LEAD LOCAL FLOOD AUTHORITY – STATUTORY CONSULTATION

Consultation on Application Number: 2017/91623

Address: Land at, Dunford Road, Hade Edge, Holmfirth, HD9 2RT

Proposal: Erection of 59 dwellings and associated means of access

DUNFORD ROAD

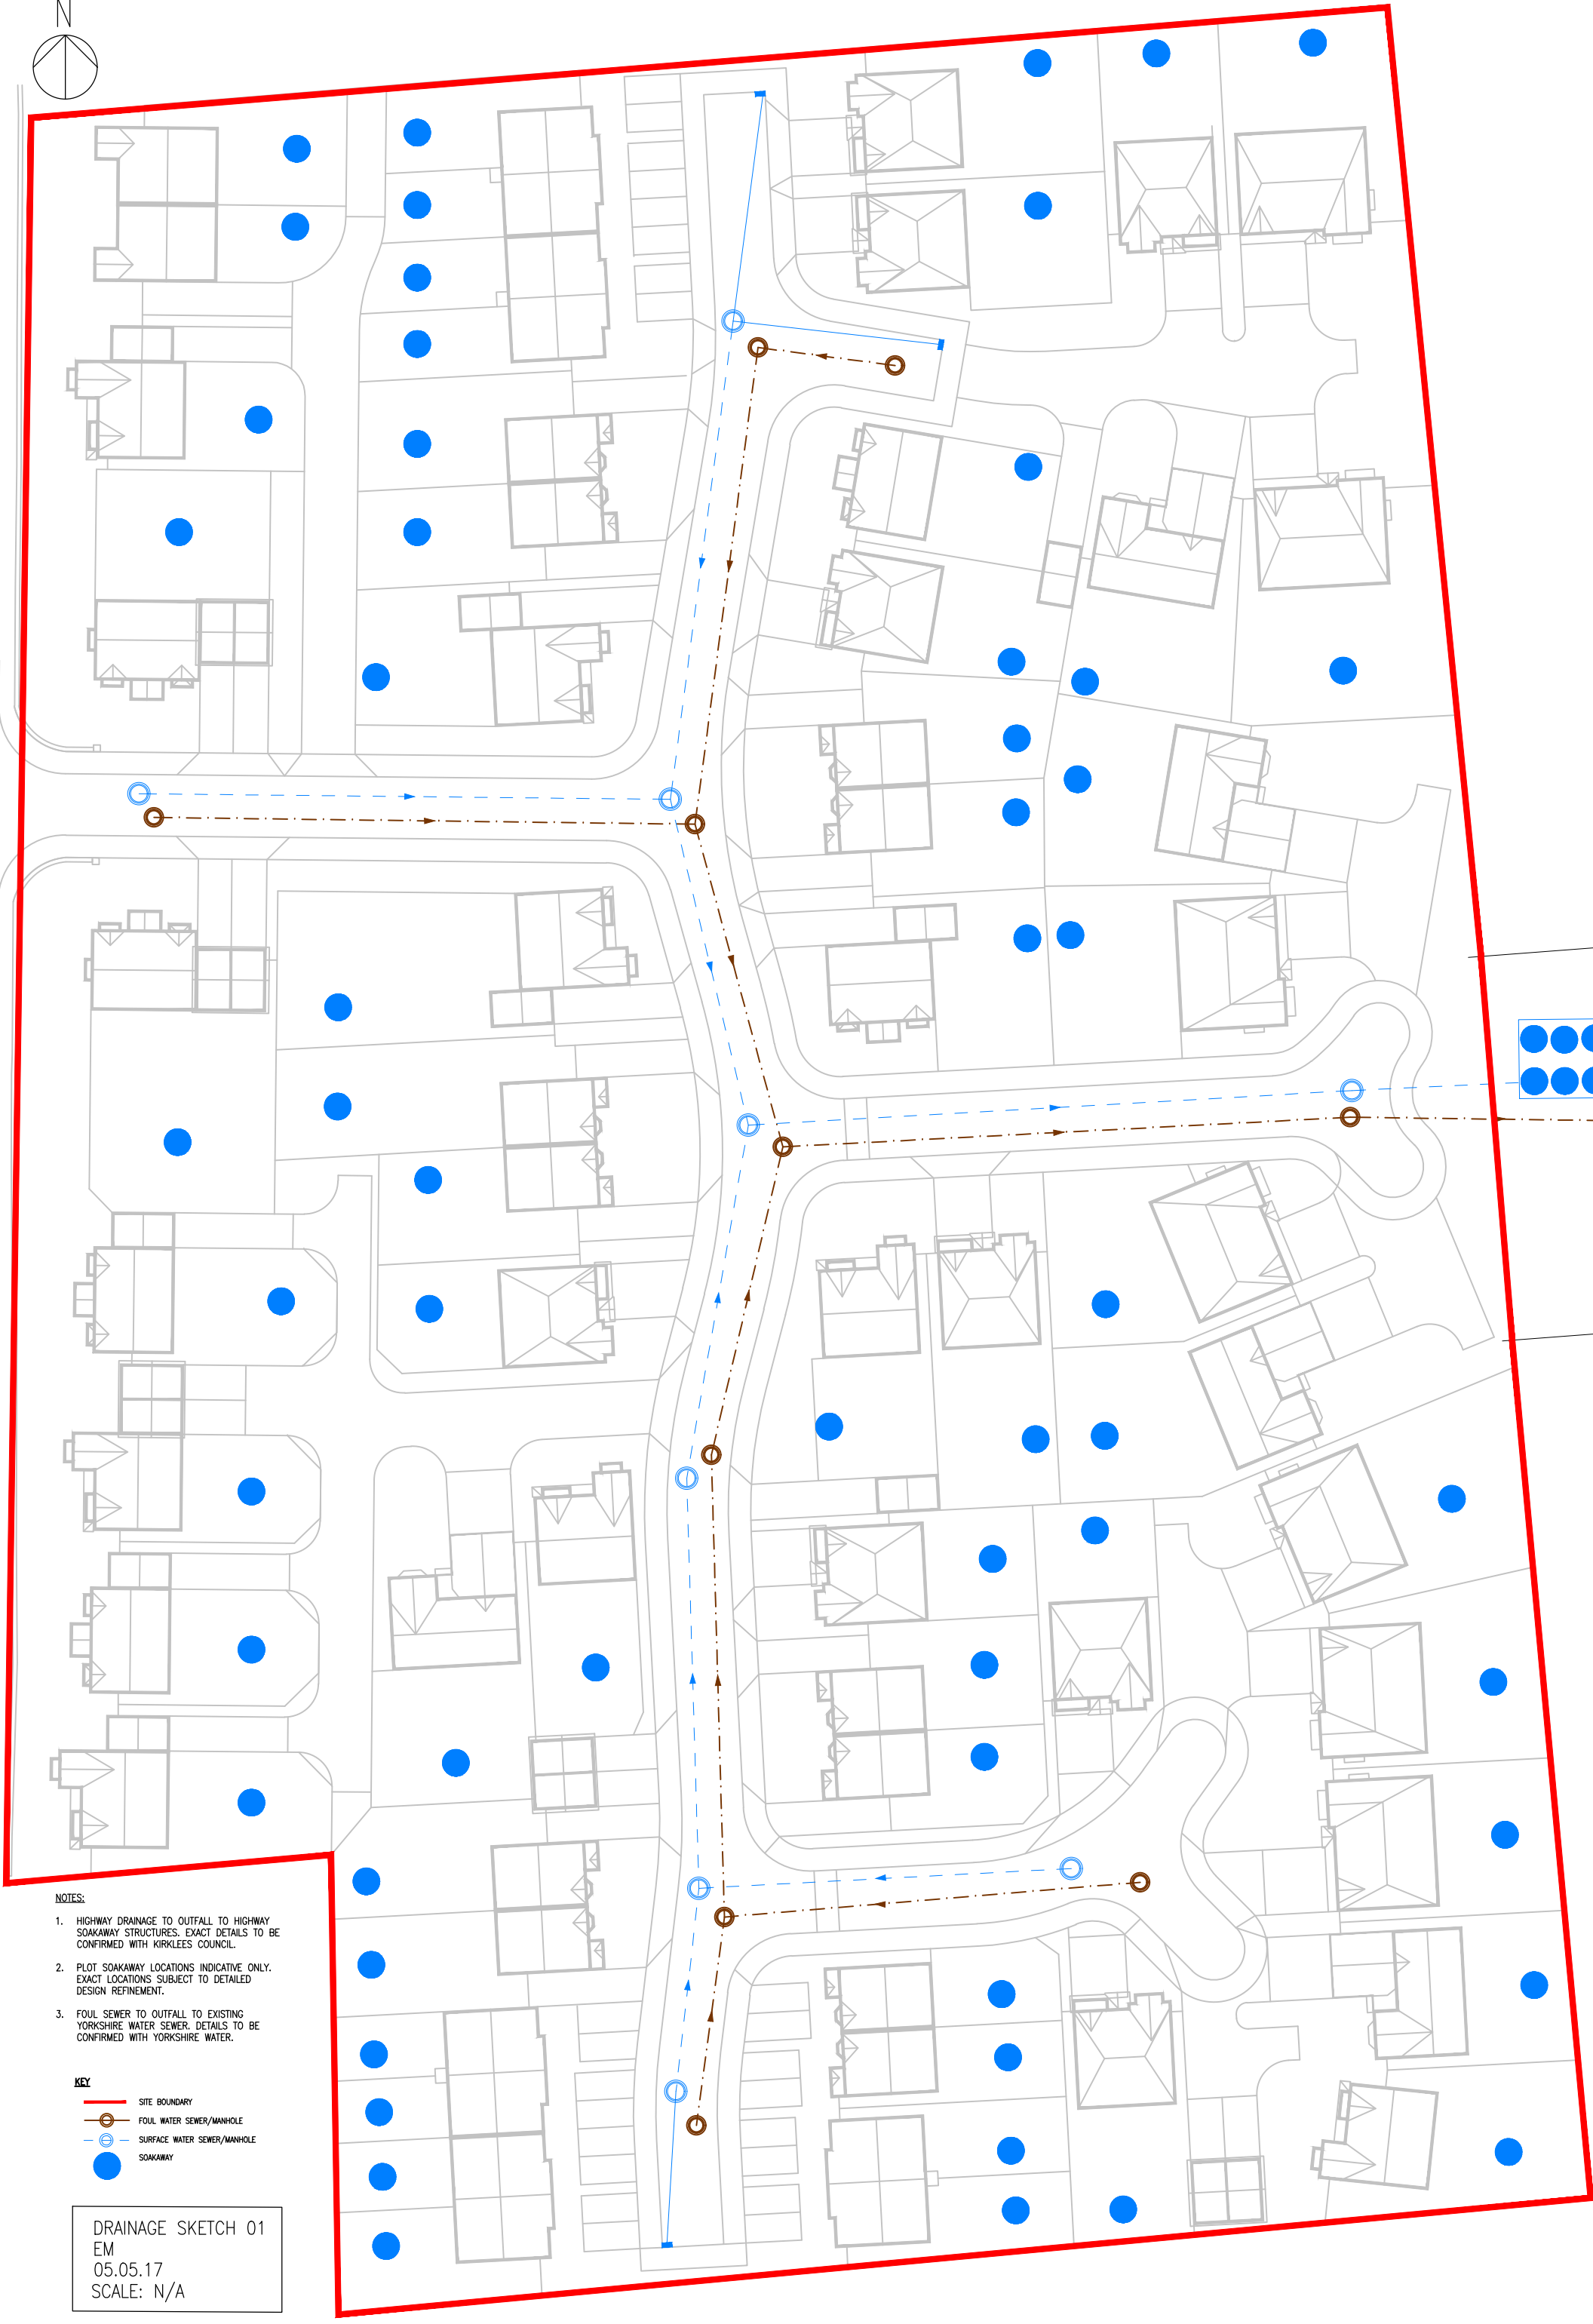
- **Highway soakways are located outside the red line boundary. Access from a practical and legal perspective need to be discussed before an approval can be given which may require layout alteration. Highways DC and Section 38 will need to comment. We expect a robust maintenance and management plan to be agreed through a section 106 undertaking/agreement that may need to be tripartite if a 3rd party landowner is involved. The LPA is obligated to ensure such drainage systems are maintained for the lifetime of the development.**
